MI TREEHOUSE, LLC
P.O. Box 261
Medina, WA 98039
T: (425) 761-5460

January 24, 2019

**RE: MI TREEHOUSE REASONABLE USE EXCEPTION APPLICATION
CAO 15-001 and SEPA15-001**

The following is submitted in response to your November 16, 2018, letter requesting additional information and documentation in connection with the above application:

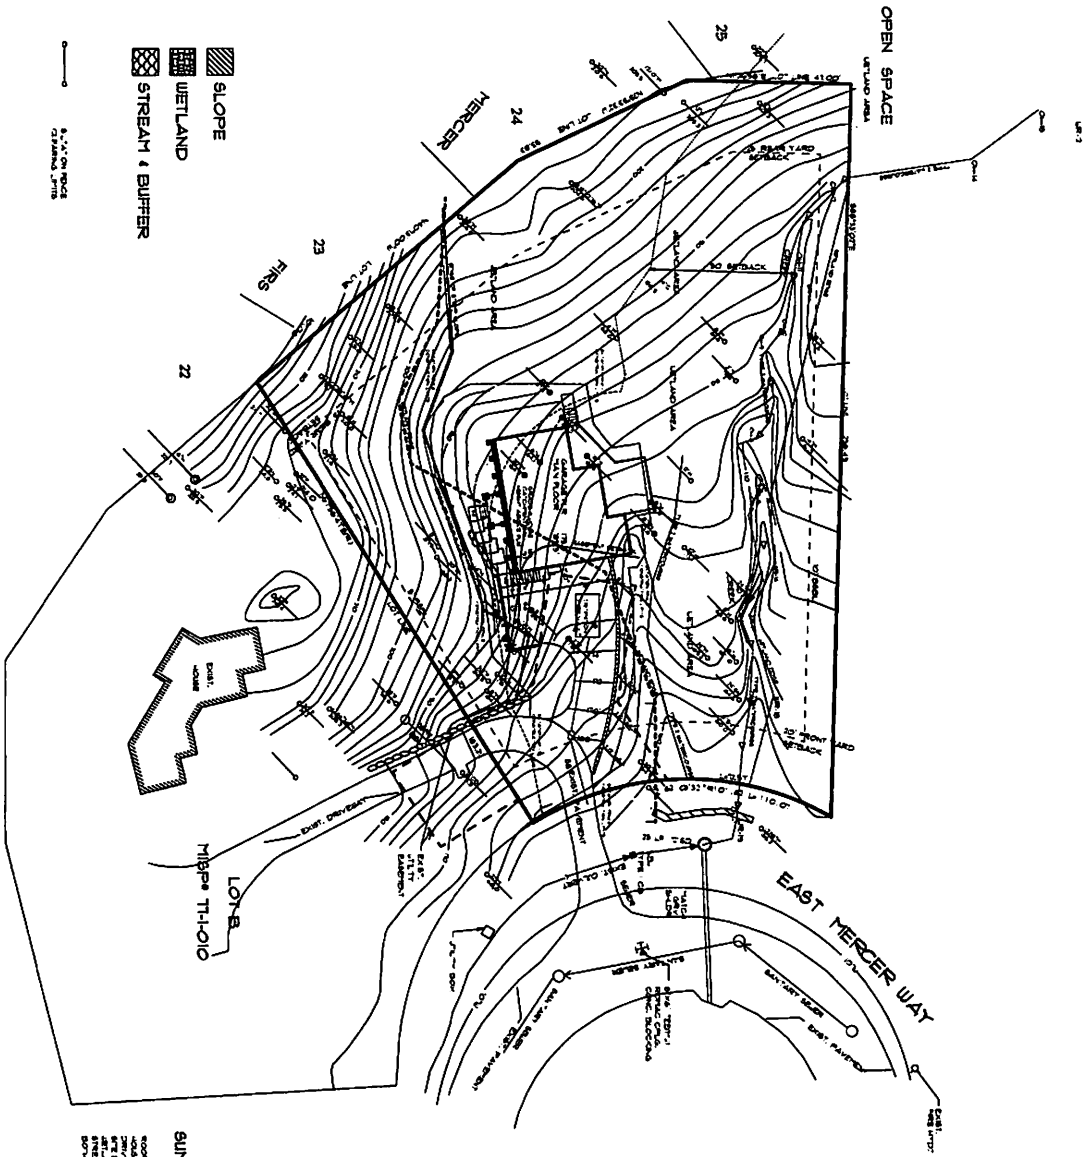
Response: As requested, all structures and grading are now considered a permanent impacts as shown on the attached Wetland and Buffer Impact Site plan dated revised 12-17-18.
